**Fingal County Council**

Planning was lodged with ABP on 20<sup>th</sup> June 2018 and received by FCC on 20<sup>th</sup> June 2018

**Dublin City Council**

**Meath County Council**

Title: **PROPOSED CULVERT AT MAYNE RIVER CROSSING - WWTP ACCESS ROAD - SHEET 1 OF 2 -**

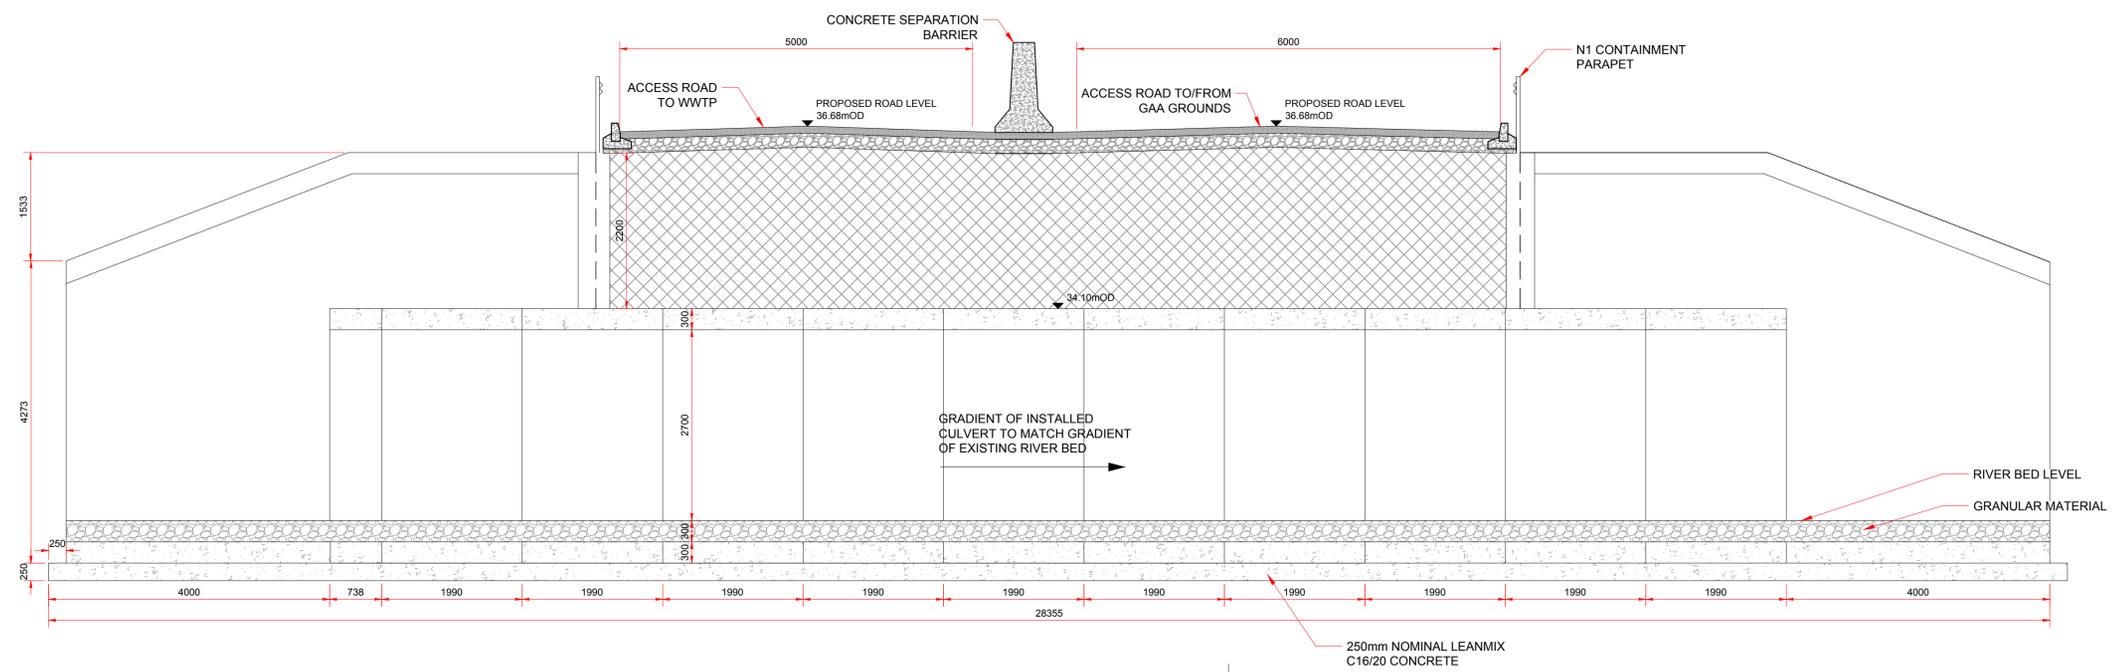
Page 62 reference to culvert of Mayne River and Inland Fisheries. (IF were not consulted regarding the culvert size increase at Mayne River as hinge to planning submitted at oral hearing)
